An Coimisiún Pleanála,
64 Marlborough Street,
DUBLIN 1
D01 V902

ACP ref : PCX12. 324290

re: Proposed wind farm of 14 wind turbines, and associated infrastructure.
Applicant : FuturEnergy Lissinagrough DAC

Title:
 Figure 2-3:
 Proposed Turbine Delivery Route

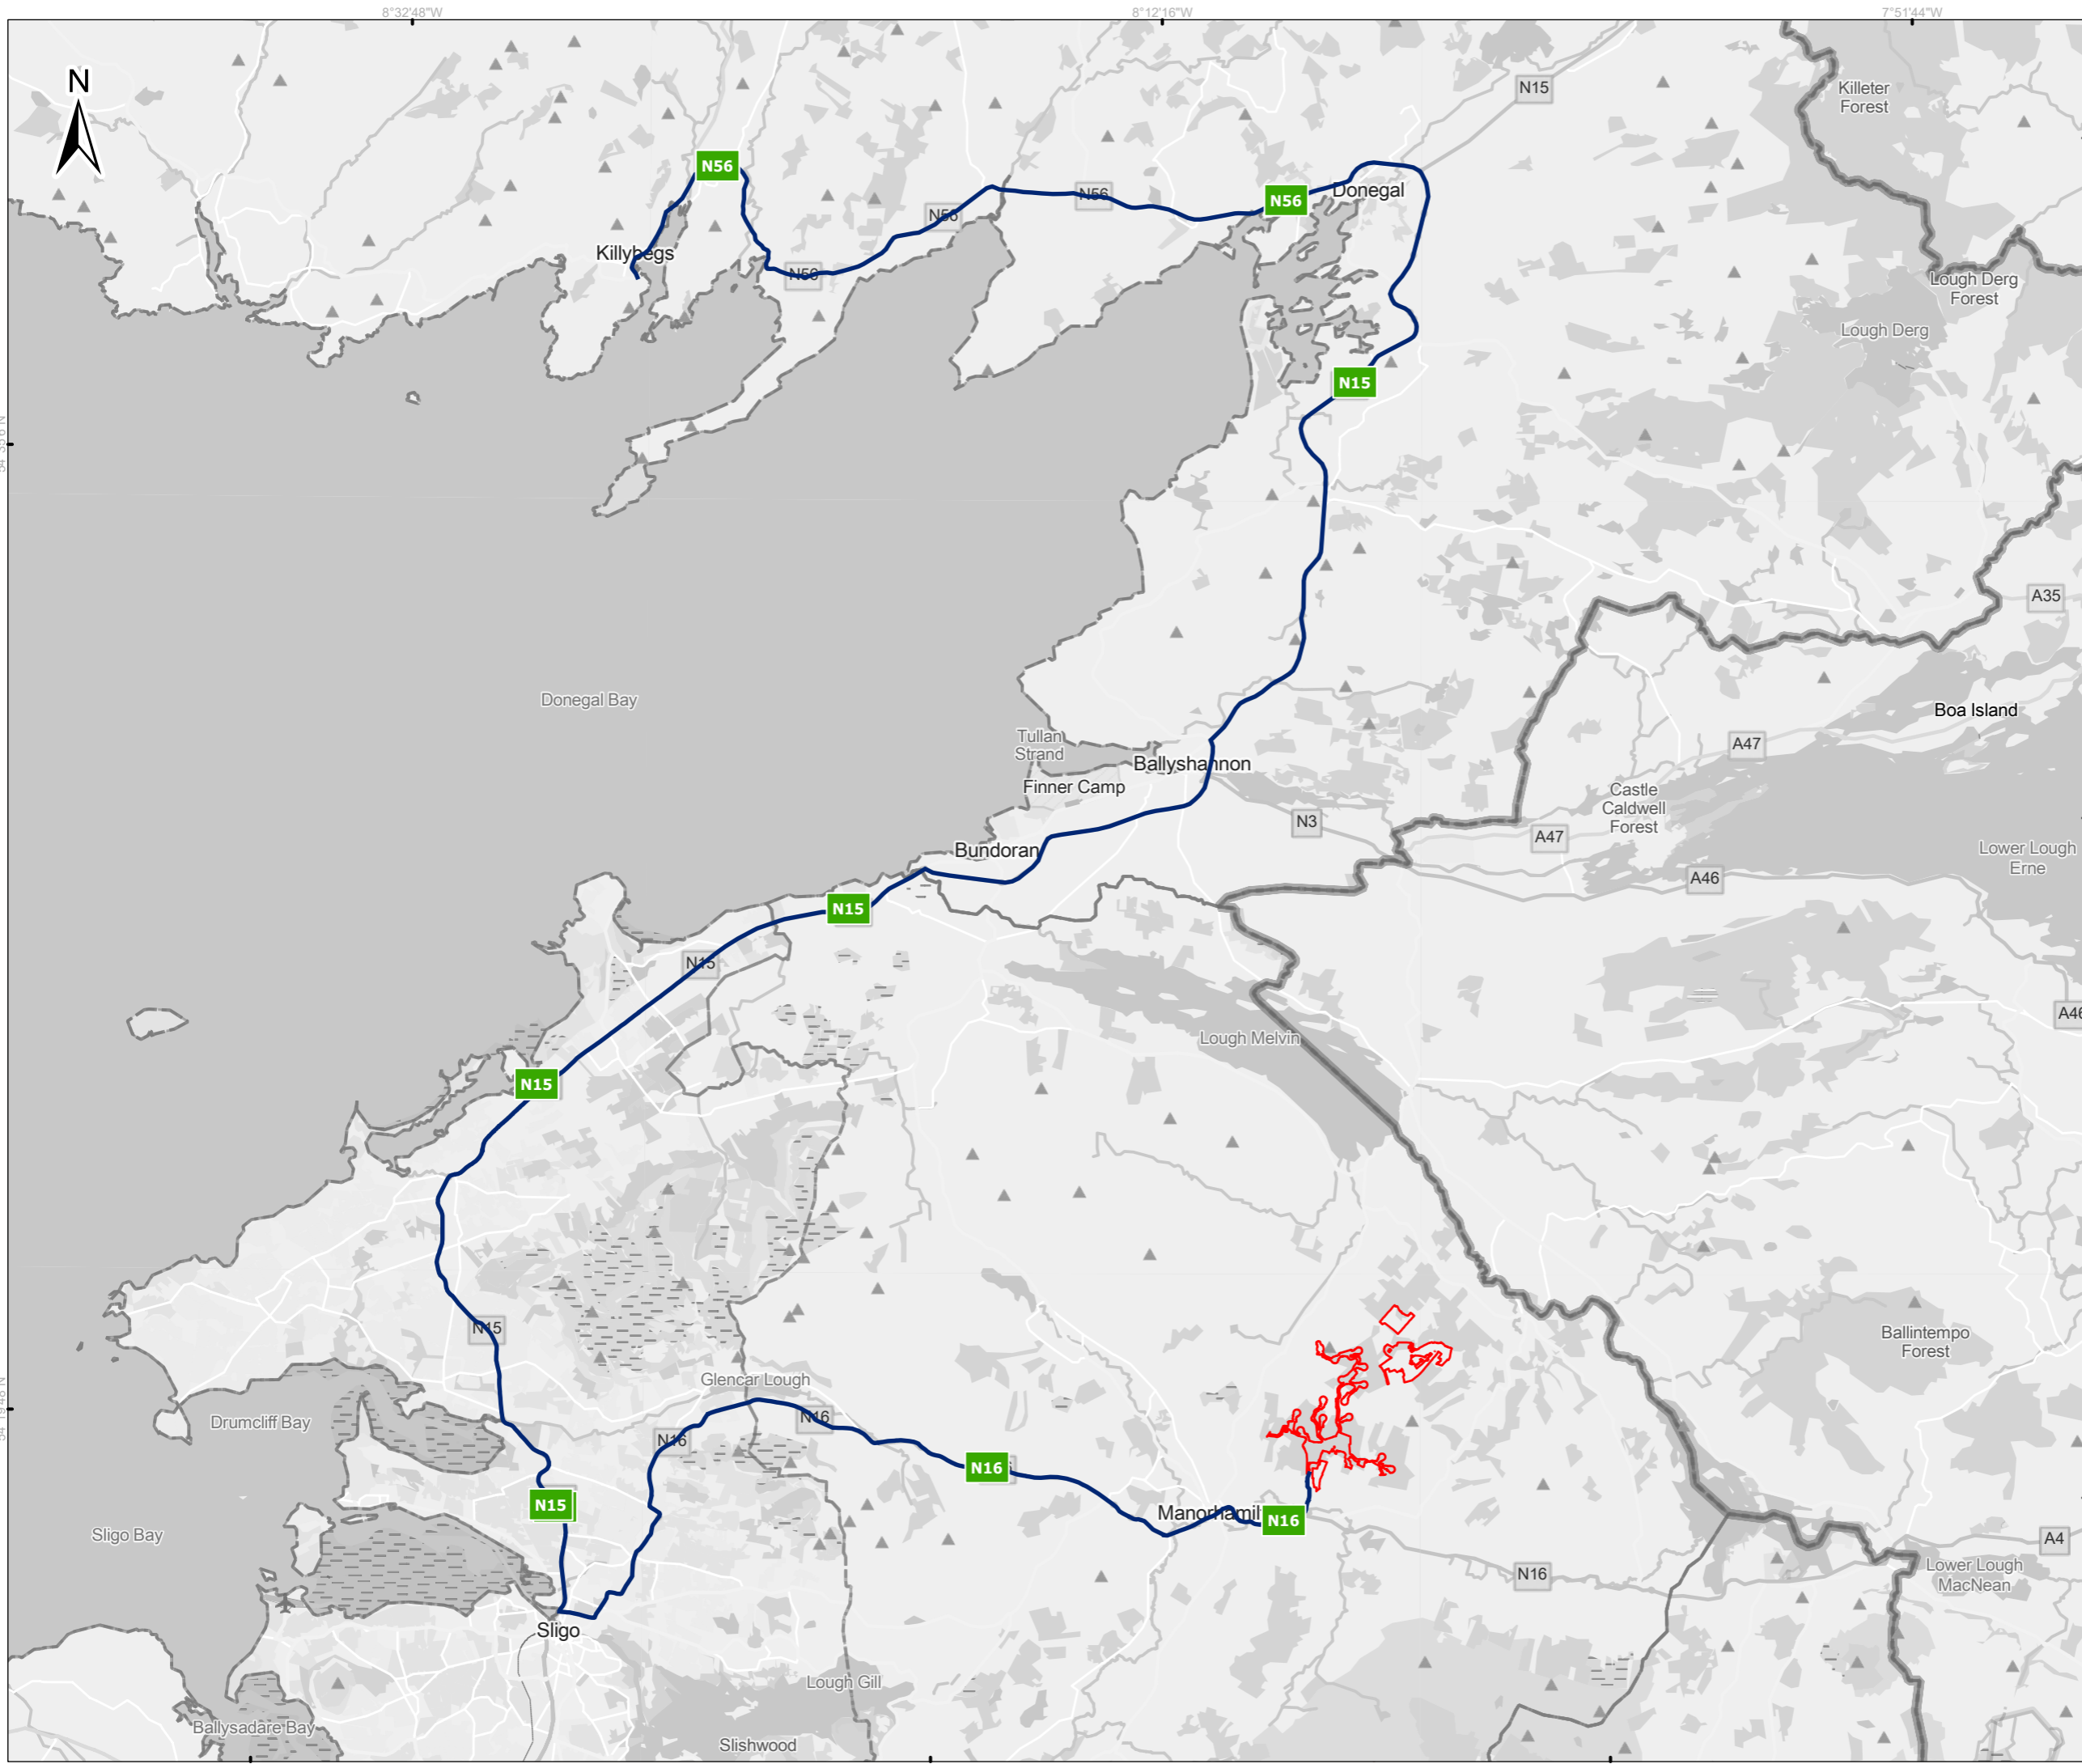
- 1.2 There is little point in seeking Permission for a Wind Farm if the turbines can't be lawfully brought onto the site. Without access across third party land, turbines cannot be brought along the route shown in EIAR Appendix 2-1

- 1.3 Let's say one farmer on the TDR gets an injunction.
The developer must then find an alternative route.
However, no alternative route is considered in the EIAR.

Importantly EIAR Appendix 2-1 does not map alternative routes - or half-routes.
The failure to consider alternatives is a fatal *lacuna*.

Figure 2-4: Turbine Front Elevation showing tip height, hub height and rotor diameter ranges (Extract from Drawing 10955-2032)

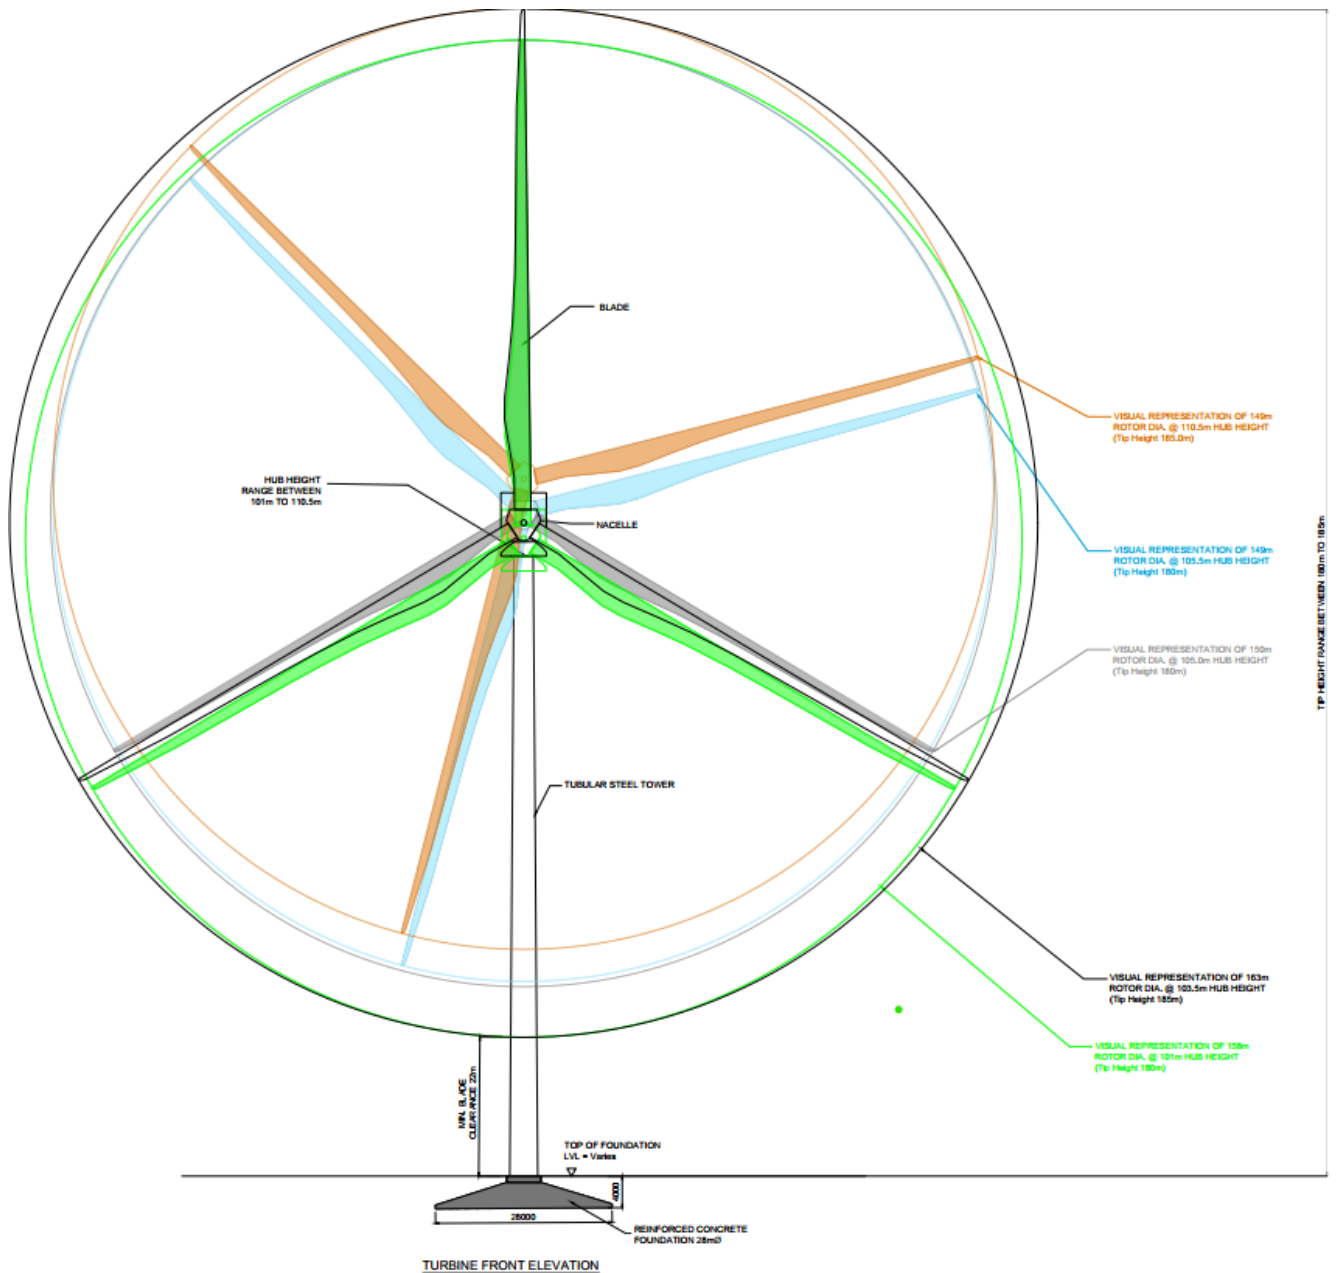
- 3.6 The proposed Buffer zones are a scientific nonsense made worse by the attached distortions between the *Mean (+SE) number of bat passes per hour and night* Diagram and the attached *Figure 2-4 elevation*.

There is no scientific evidence to support increased [Buffer] zone applicable formulae in Ireland or UK.

This is a scientific gap or *Lacuna*.

Turbine Dimensions	
Turbine Height	180m - 185m
Rotor Diameter	149m - 163m
Hub Height	101m - 110.5m

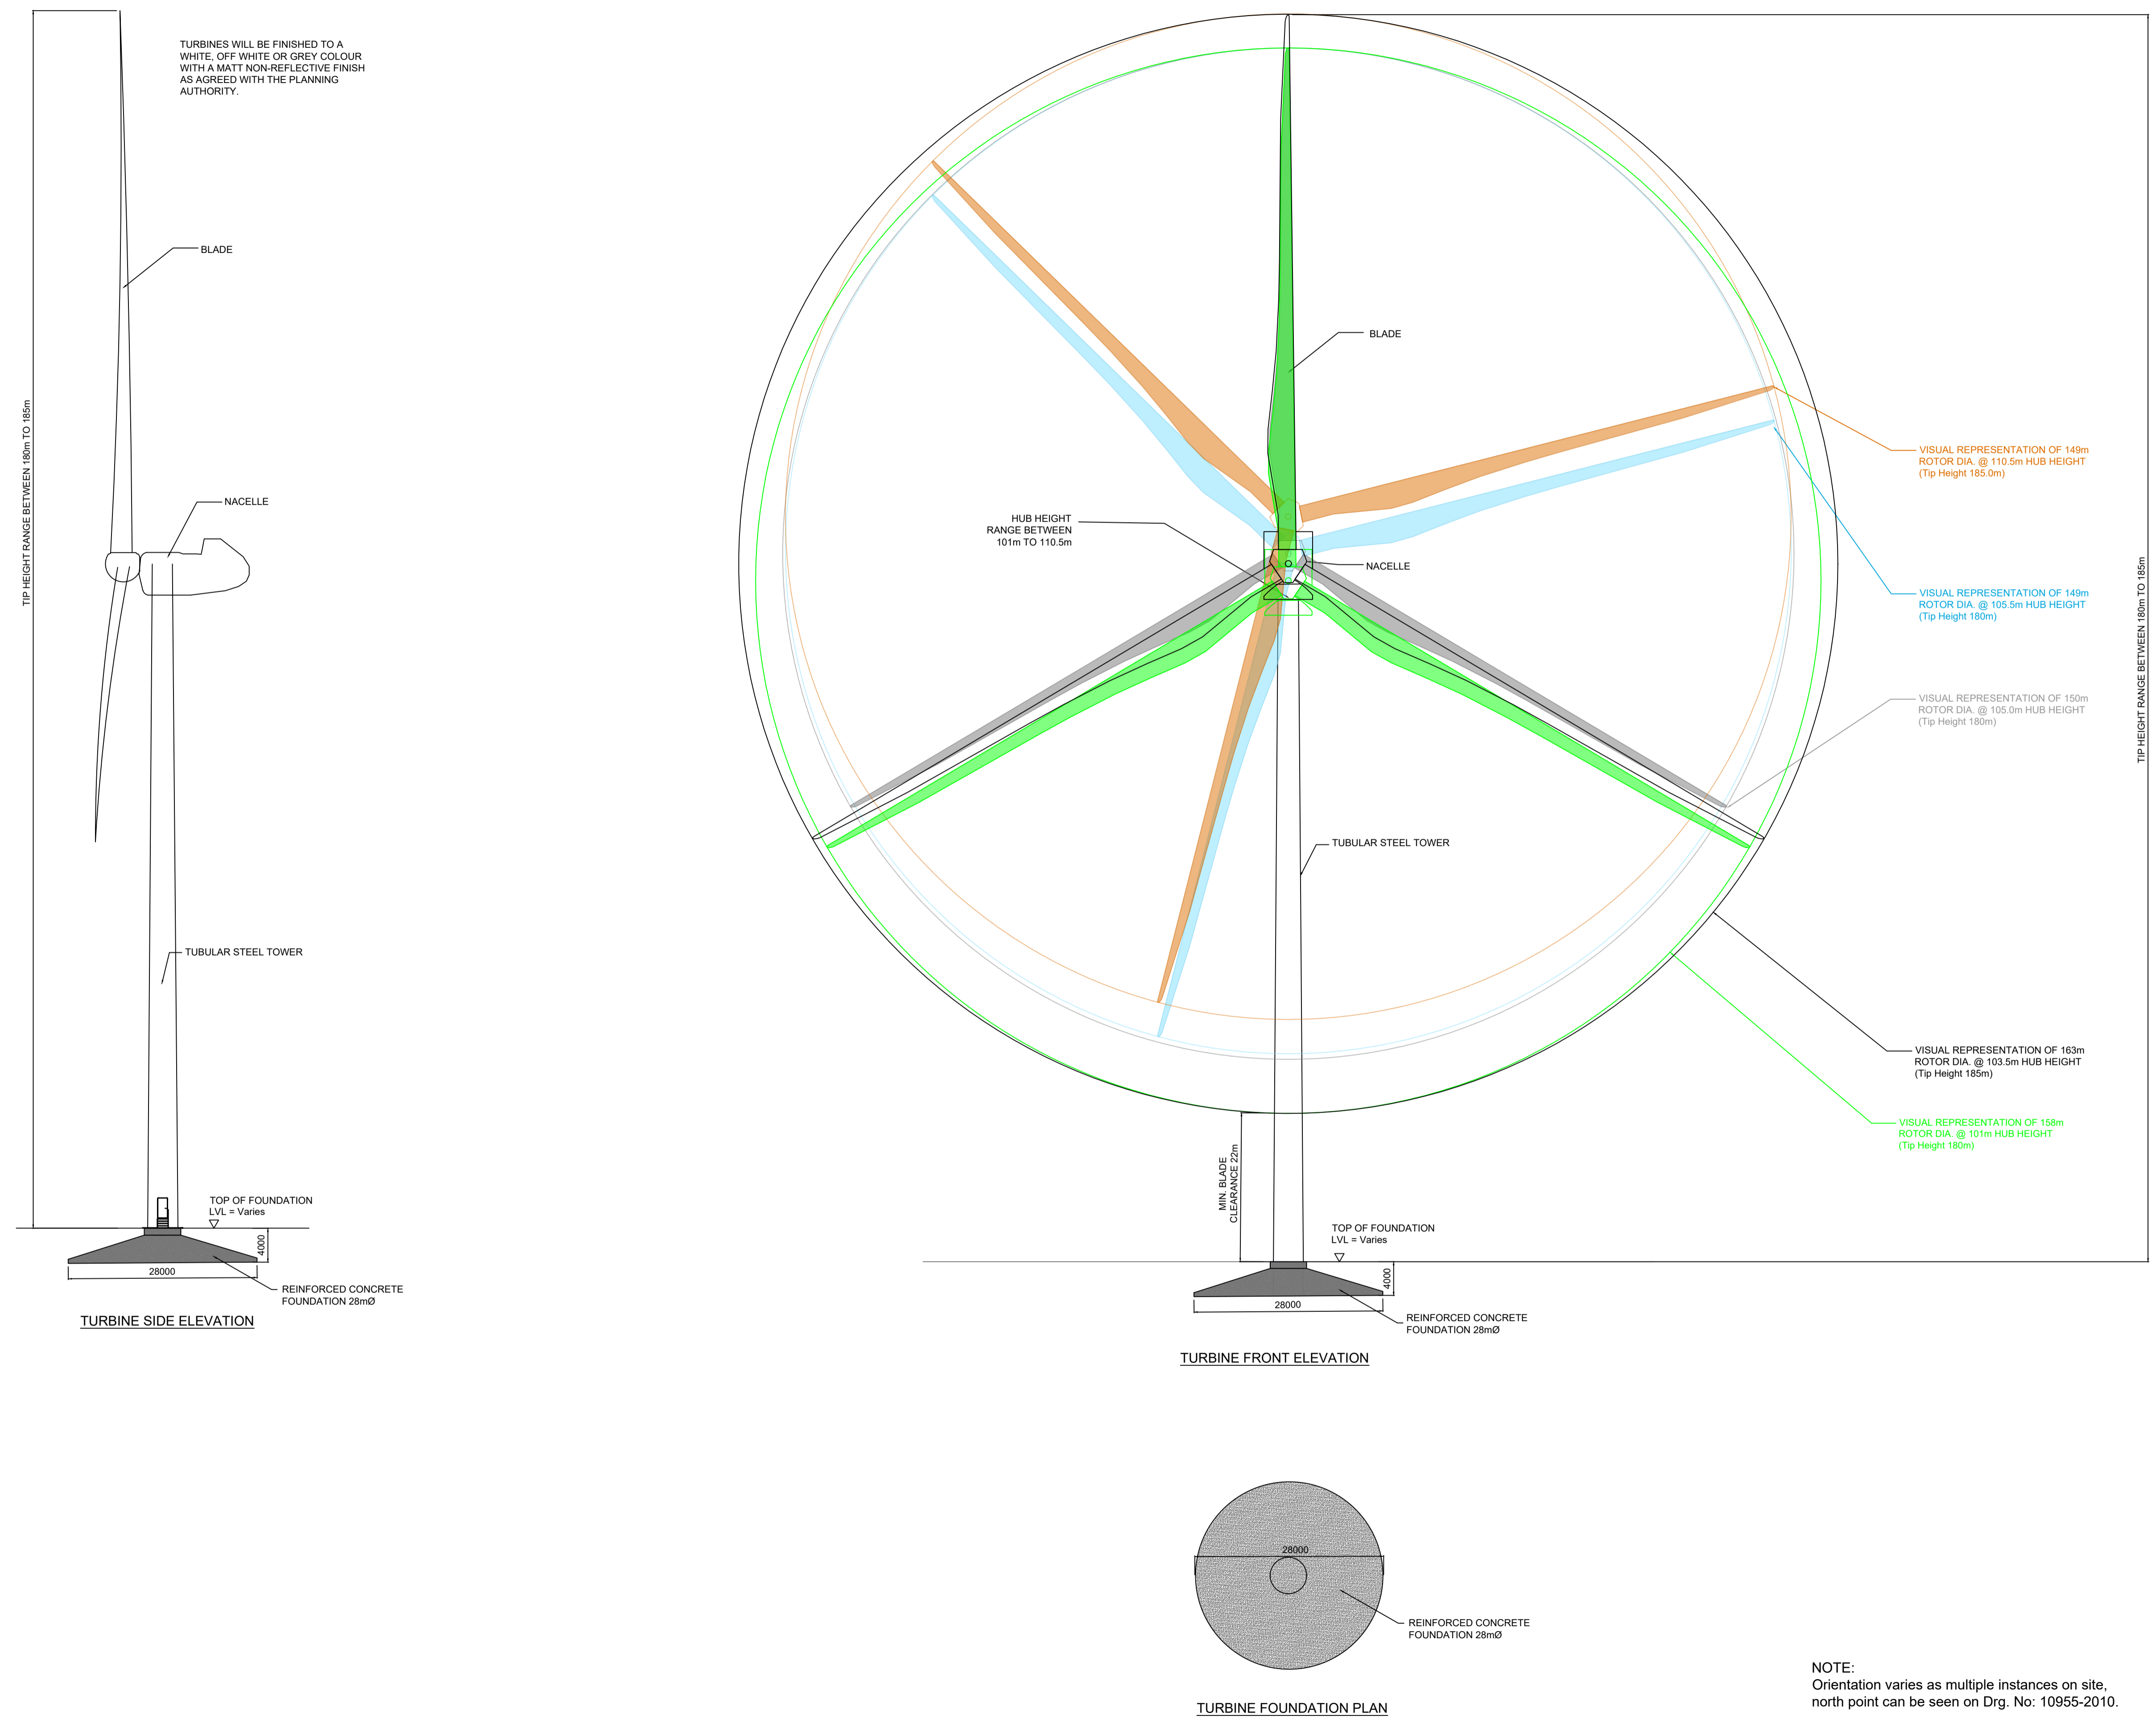
- (i) Bats travel by sonar navigation.
Whether sonar navigation is or is not affected by air turbulence from Wind Turbines has not been assessed. This is especially important because the tips of the rotor blades travel 22m above ground level and well within the flight path corridor height of Bats. Moreover, the tips of the rotor blades at 22m above ground level have a velocity of over 500 km/hour.

- 5.1 The applicant relies on Section 37CC of the Act permitting Design Flexibility within specified broad parameters.

If the actual details and the Turbine Model No. are not specified, the de-commissioning study cannot be complete, precise and definitive. There are scientific gaps.
